To: El Paso County  
From: Sean Hays, PE  
Kimley-Horn and Associates, Inc.  
Date: August 13th, 2021  
Subject: Design Documentation - Proposed Roundabout at Meadowbrook Pkwy and Newt Dr

**MEADOWBROOK PARKWAY ROUNDABOUT**

**MEADOWBROOK PKWY & NEWT DR**

MEADOWBROOK ROUNDABOUT BICYCLE PLAN

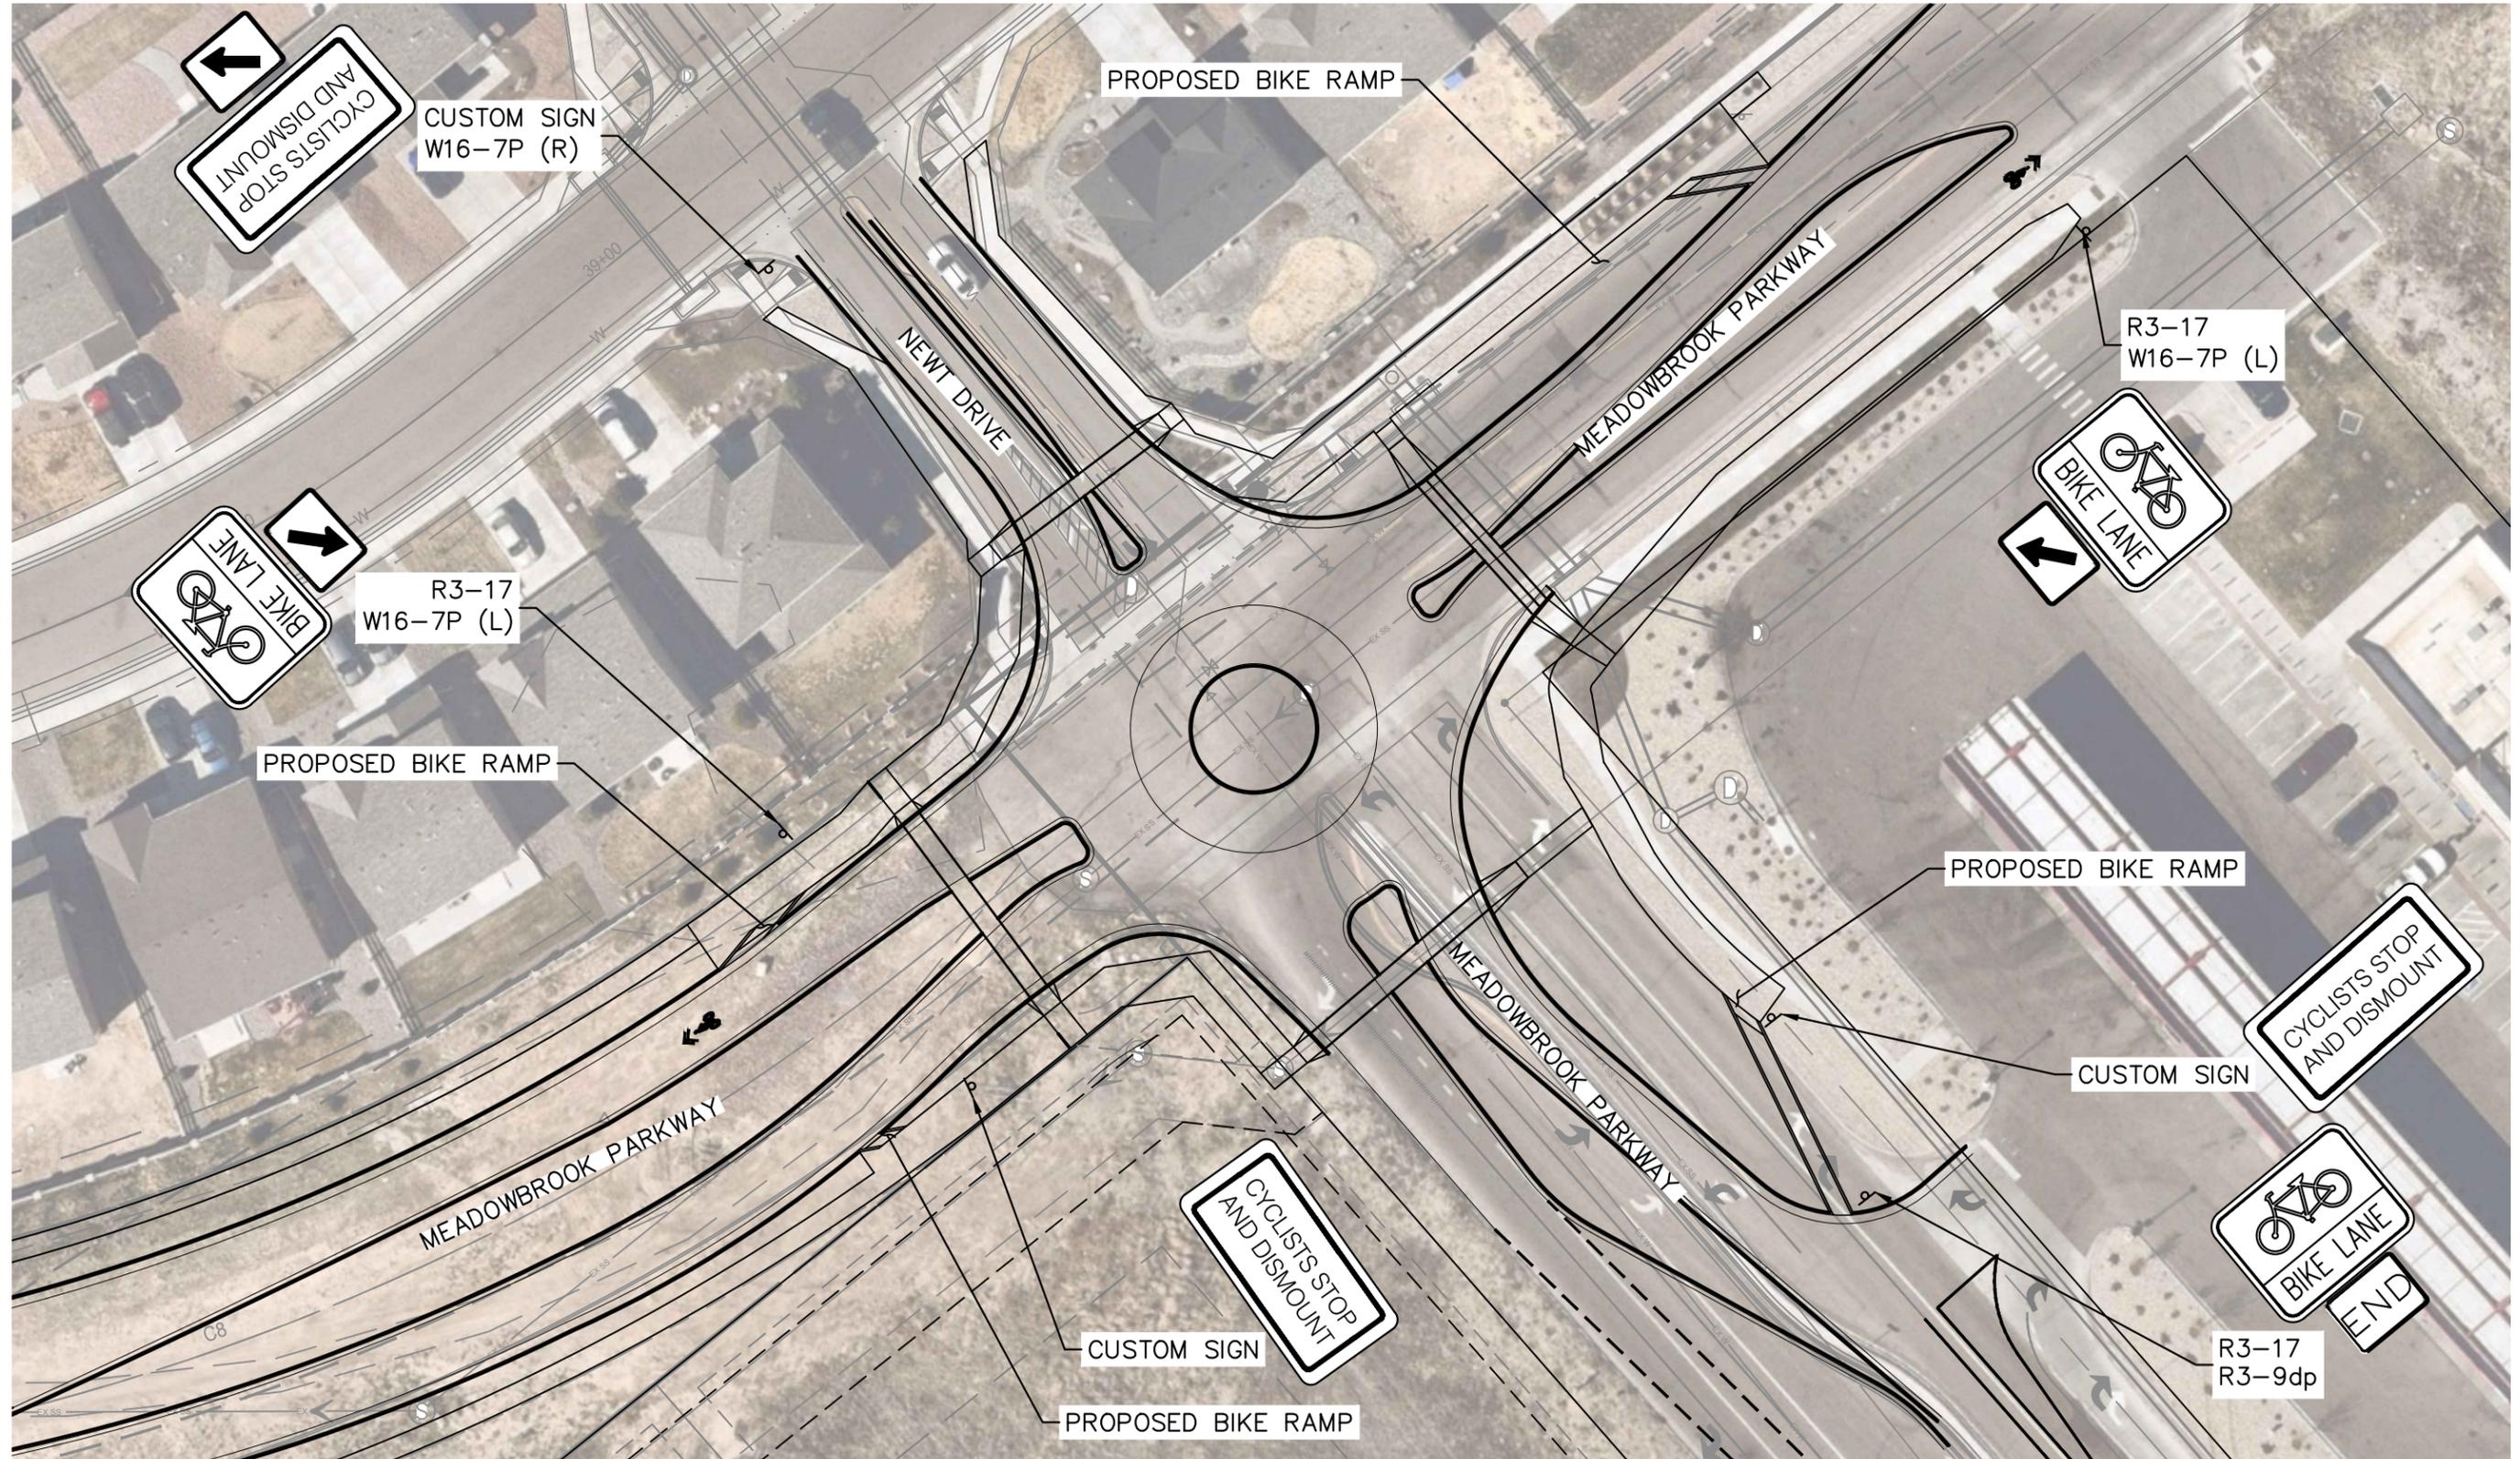
Update Roundabout to include Bike entrance and exit ramp design.  
See the WiDOT roundabout design for standard width for the shared-use path.

After discussions with the Engineering Review Manager and County Engineer regarding the Roundabout Comment Response, the County will require the bike facility at the roundabout (bike ramp & pedestrian/bike shared-use path). The omission of the refuge area at the splitter island is acceptable.

Unresolved. See the attached email below for County's response.
